CITY OF ALBUQUERQUE

July 8, 2020

Re: Master Tech Automotive
304 Candelaria Rd NW
Traffic Circulation Layout
Architect's Stamp 07-06-2020 (G14-D093)

SHEET  
T-1

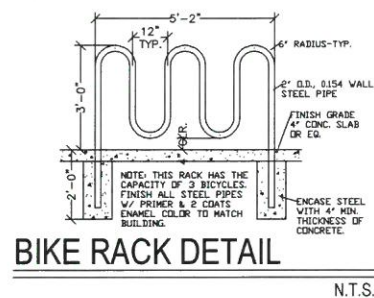
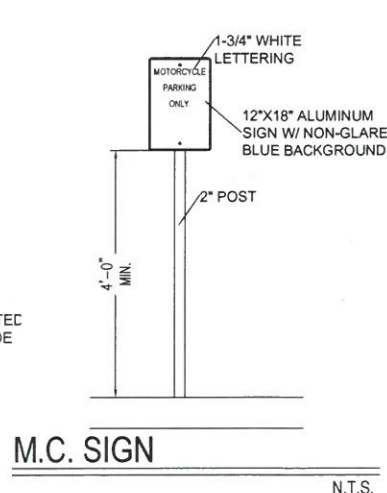
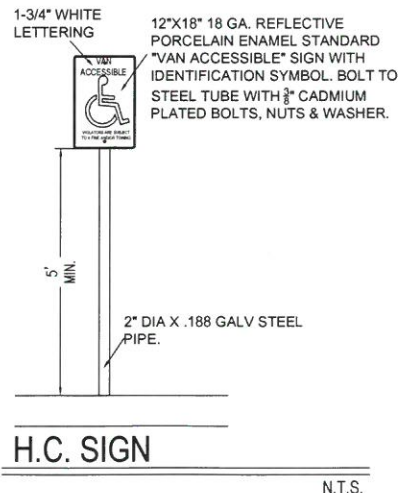
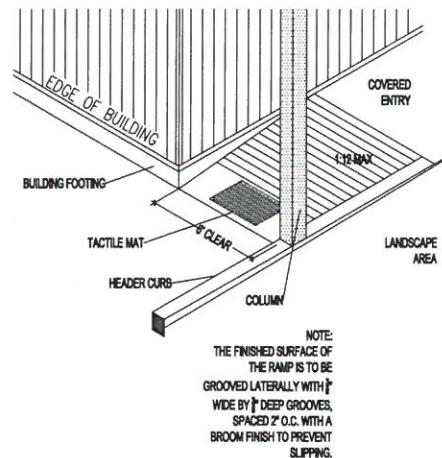
1. Coordinate with Zoning(**IF APPLICABLE**): the number of parking spaces required by the zoning code as well as the proposed number of parking spaces including bicycle and motorcycle parking.
2. The ADA parking stall is too close to the entrance off Candelaria Road. You need a 50 feet set back from flow line of Candelaria before you can provide parking stall. Per DPM Throat depth requirements off an Arterial road.
3. Identify the medians and street widths on Candelaria Road NW.
4. Your proposed driveway and 6 inch curb don't line up on the egress. Please address this concern.
5. What is the width of existing sidewalk fronting Candelaria Road? Please provide width.
6. Please list the length for all proposed parking spaces. Some dimensions are not shown.
7. The minimum parking stall dimensions are:

8. Motorcycle parking space: Label pavement MC.

13. Show all radii's. Some are not shown.

14. List radii for all curves shown; for passenger vehicles. Radius for delivery trucks, fire trucks, etc. is 25 ft. or larger.

15. Per DPM, a 6 ft. wide ADA accessible pedestrian pathway is required from the ADA parking stall access aisles to the building entrances. Please clearly show this pathway and provide details. This includes ADA ramp width.

16. Parking areas shall have barriers to prevent vehicles from extending over abutting lots.
